RE: Letter of Intent– MVEA Vollmer South

Mountain View Electric Association, Inc (MVEA) will be constructing a 12.5 kV underground electrical distribution feeder line running along the east side of Vollmer Road. The underground installation will be approximately 1.75 miles in length and will begin near the intersection of Vollmer Road and Poco Road. The installation will run south parallel to Vollmer Road within a platted 20' utility easement until reaching Briargate Parkway. It continues southeast along the southeast side of Briargate Parkway in a platted 20' utility easement. The line then crosses and terminates along the southeast side of Wheatland Drive.

VICINITY/SITE MAP OF NEW UNDERGROUND ELECTRICAL DISTRIBUTION LINES
**NOT DRAWN TO SCALE*

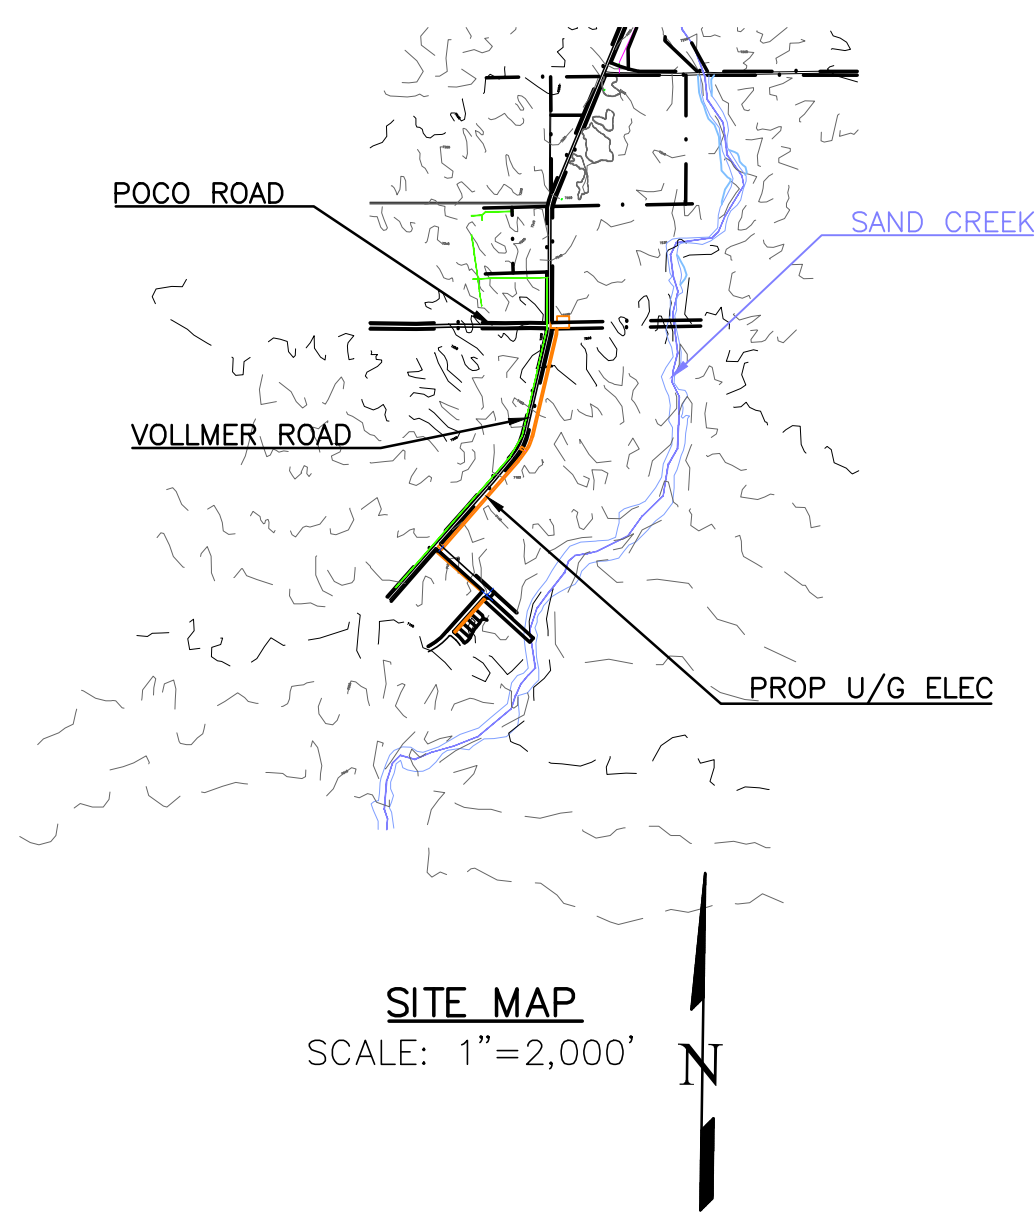
Are these easements platted within the public ROW? The lot east of Vollmer Rd has not been platted yet.
